Our Case Number: ABP-316212-23

Re: Proposed development of 26 wind turbines and associated works
at the Ballivor Bog Group, County Meath and County Westmeath

Dáta | Date
31 May 2023

RE.: Proposed development of 26 wind turbines and associated works at Ballivor Bog Group, County Meath and County Westmeath

Figure	14-1	Site	location	and	delivery	routes
--	--------	------	------	----------	-----	----------	--------

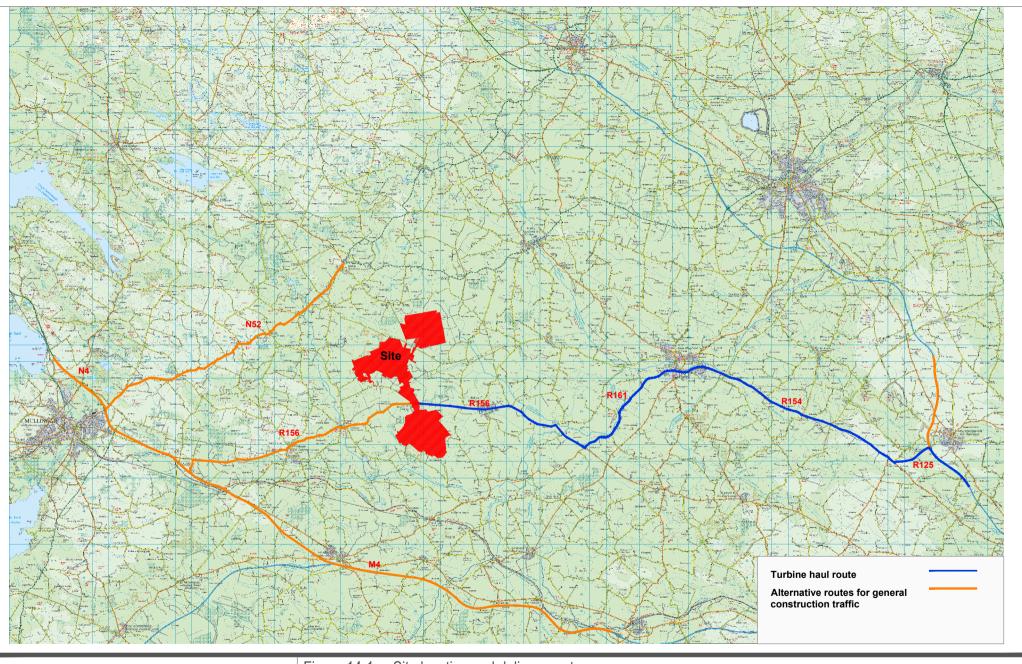
Proposed Turbine Delivery Route (TDR) at subsection 14.1.2.2 of the submitted EIAR identifies that turbine components will be delivered into a sea port, yet to be identified. The turbine haul route is stated to access the site from the M3 motorway via Junction 6 (Dunshaughlin) with the R125 for onward transport of turbines across the local road network.

Subsection 14.1.7 *Route Assessment* of the submitted EIAR describes assessment of the turbine haul route from Junction 6 of the M3. Subsection 14.1.7.1 of the submitted EIAR identifies temporary widening works to the Junction 6 of the M3 to facilitate this route. Works are stated to include temporary removal of road signs.

- Where temporary works within any MMaRC Contract Boundary are required to facilitate the transport of turbine components or construction traffic to site, the applicant/developer shall contact thirdpartyworks@tii.ie in advance, as a works specific Deed of Indemnity will be needed by TII before the works can take place.

- Any proposed works to the national road network, including signage, to facilitate turbine component delivery to site shall comply with TII Publications and shall be subject to Road Safety Audit as appropriate. Works should ensure the ongoing safety for all road users and prior to any development necessary licenses, approvals or agreements with PPP Concessions, Motorway Maintenance and Renewal Contracts (MMaRC) Companies and local road authorities, as necessary, shall be in place.

- Any damage caused to the pavement of the existing national road due to the turning movement of abnormal 'length' loads (e.g. tearing of the surface course) shall be rectified in accordance with TII Pavement Standards and details in this regard shall be agreed with the Road Authority prior to the commencement of any development on site.
